Recommendation Report for Planning Permission for Works or Extension to a Dwelling

REF NO: LU/408/21/HH

LOCATION: 1 Thames Close
Littlehampton
BN17 6PZ

PROPOSAL: Erection of single storey side extension and weatherboarding.

Drawing No.	Revision
1514/P02	D

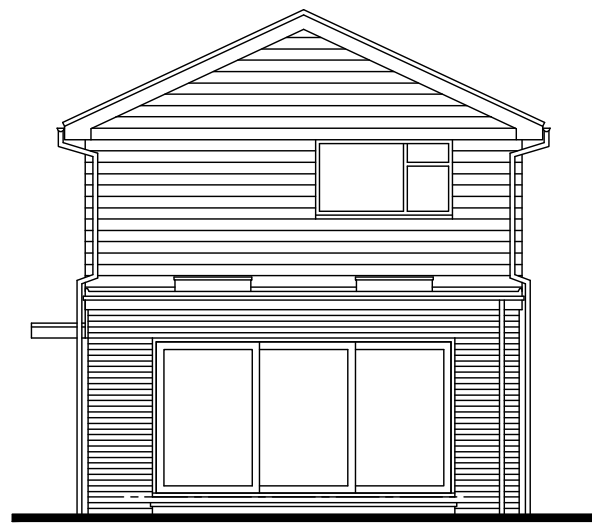
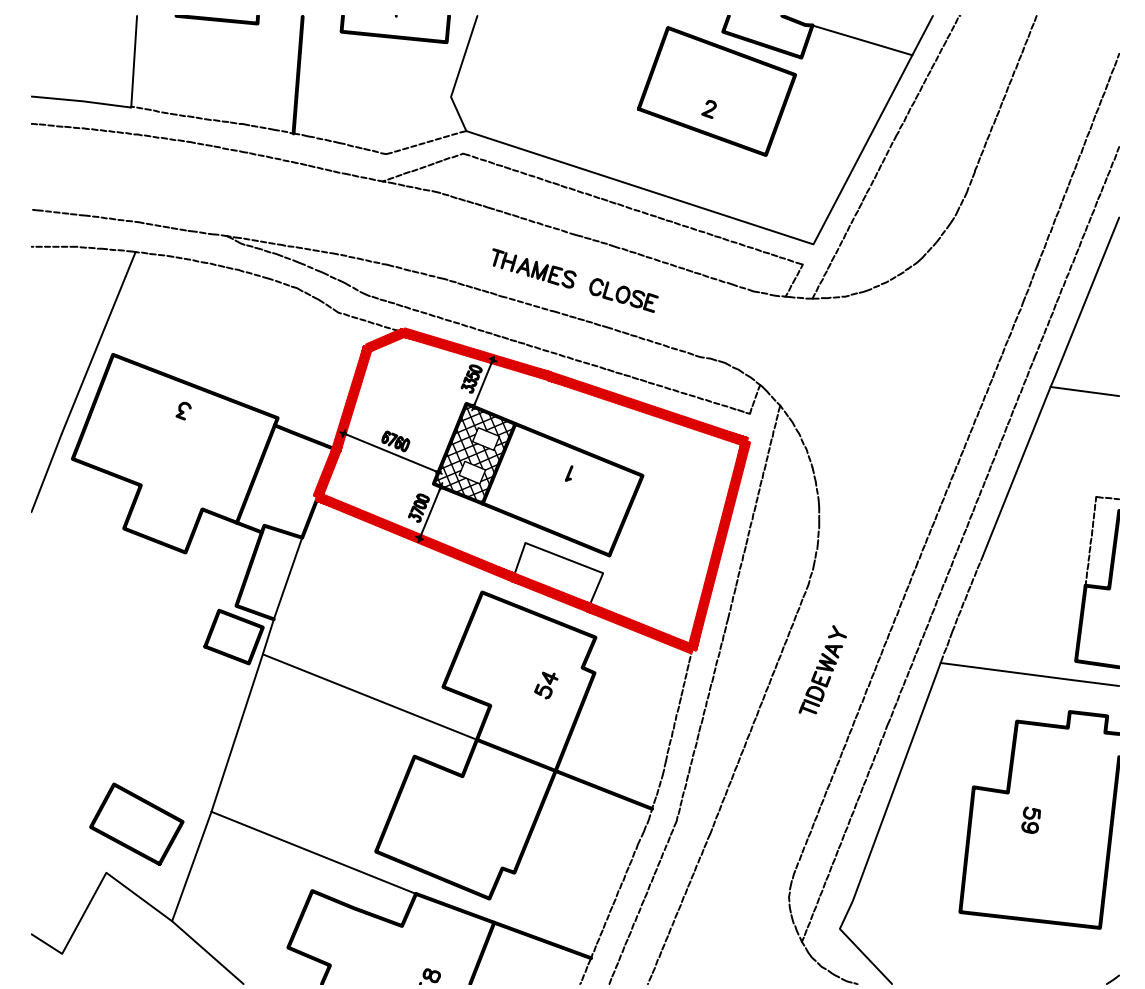
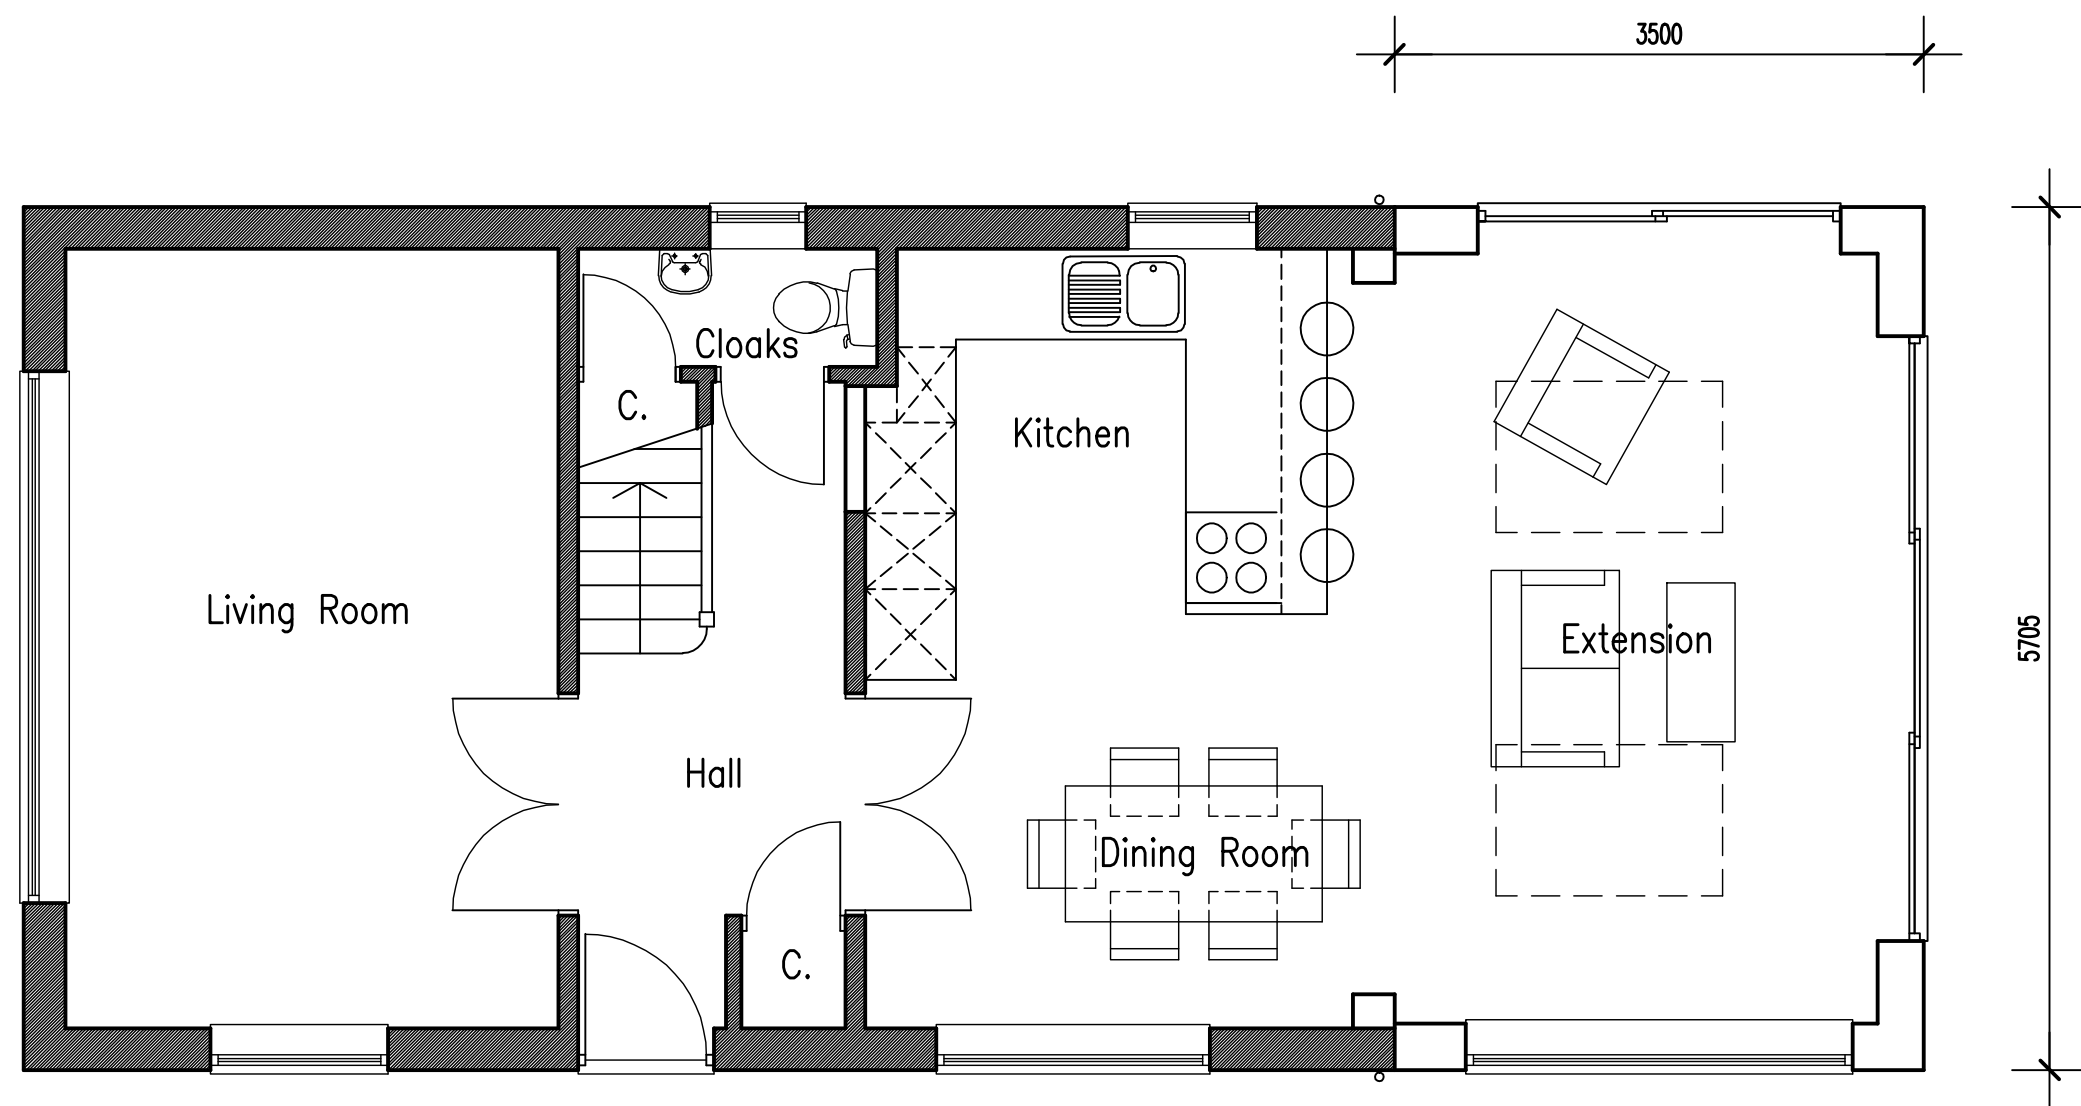
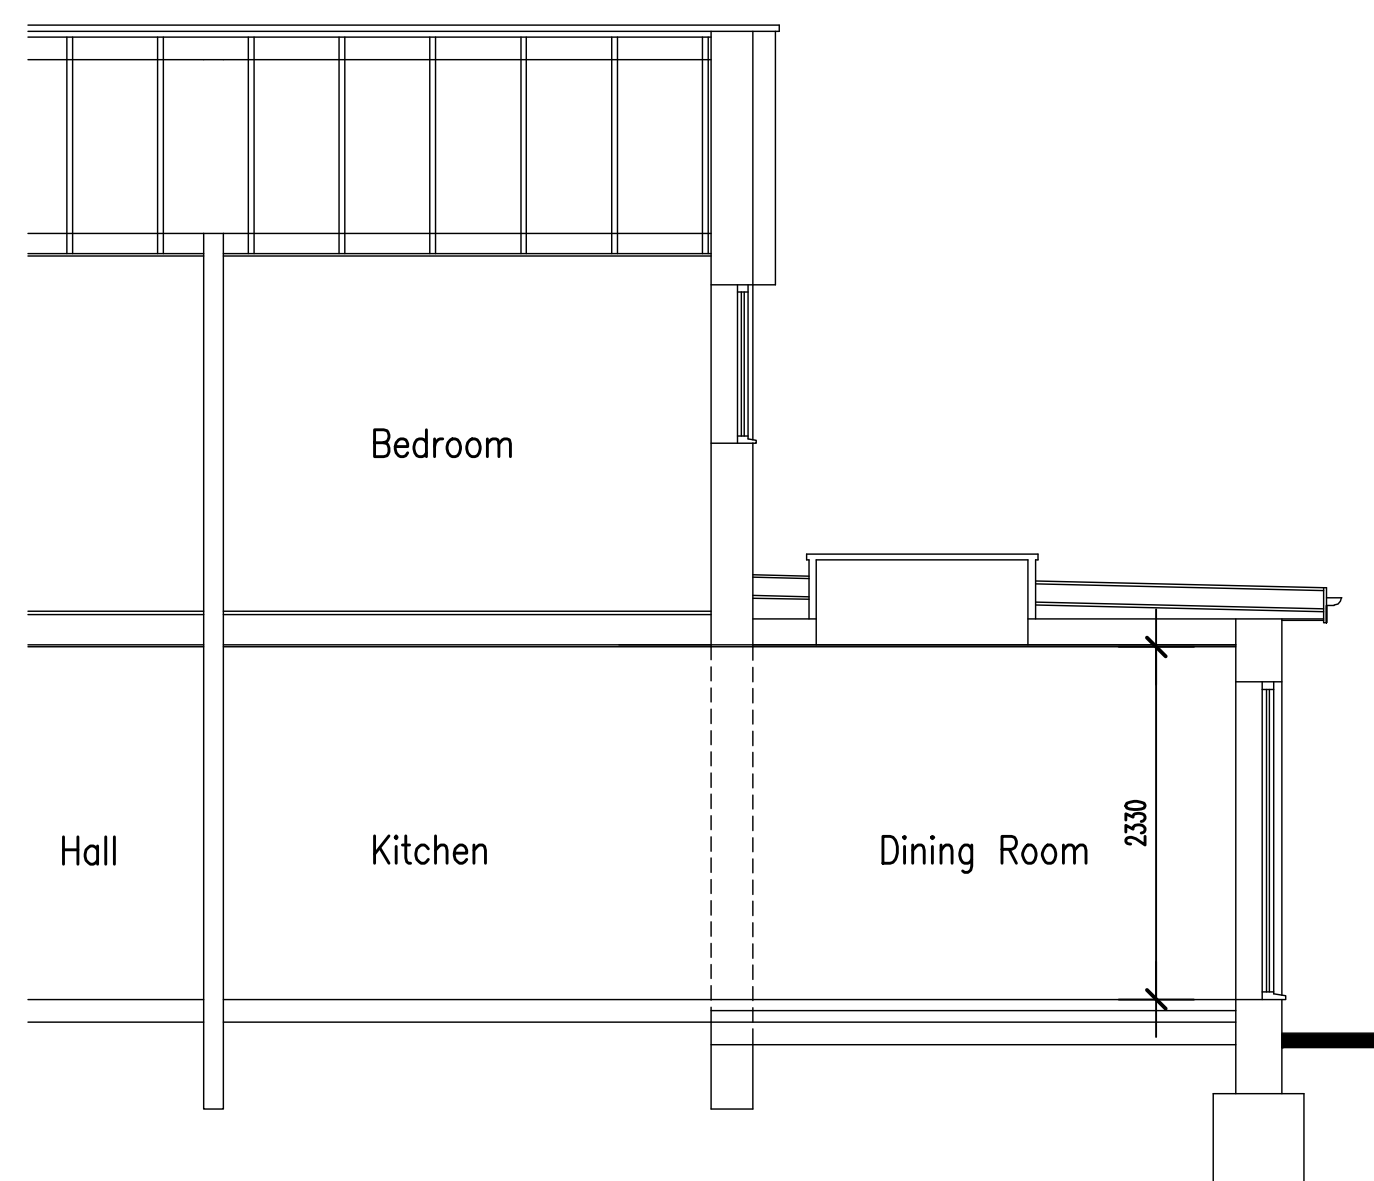
The side extension will replace an existing conservatory and be 5.705m wide and 3.5m deep. It will have a flat roof which, although differing to the existing main gable roof, is unobtrusive and will not be unduly harmful to visual amenity. It retains a distance of 3.35m to the front boundary and will be partially visible from the street scene to the front. The property itself features a brick wall around the sides and rear, which will restrict the visibility of the extension and reduce its impact on the street scene. The street scene of the local area has a varied style and composition, comprising of detached and semi detached bungalows and two storey dwellings. The extension, given its scale and design, is in keeping with the general character of the area and will have minimal impact on the composition and rhythm of the street.

The extension is to the west of the property and be single storey. It will have a height of around 3.05m at

the point where it meets the host dwelling, and a height of 2.95m at the eaves. It will feature two rooflights which protrude slightly higher than the proposed roofline, with a height of around 3.15m. The extension retains a distance of 6.76m to the west boundary and 3.7m to the south. Considering its scale and sufficient distances from the neighbouring boundaries, the development will not be unduly overbearing and will have minimal impact on residential amenity. This is in accord with D DM4.

The proposal features two rooflights, two sliding doors to the south and west elevations, and a window to the north. These features are well placed and do not unacceptably overlook or intrude neighbouring properties, given they are located on the ground floor. They are not directly in line with any windows of neighbouring properties and pose little risk to neighbouring privacy and amenity.
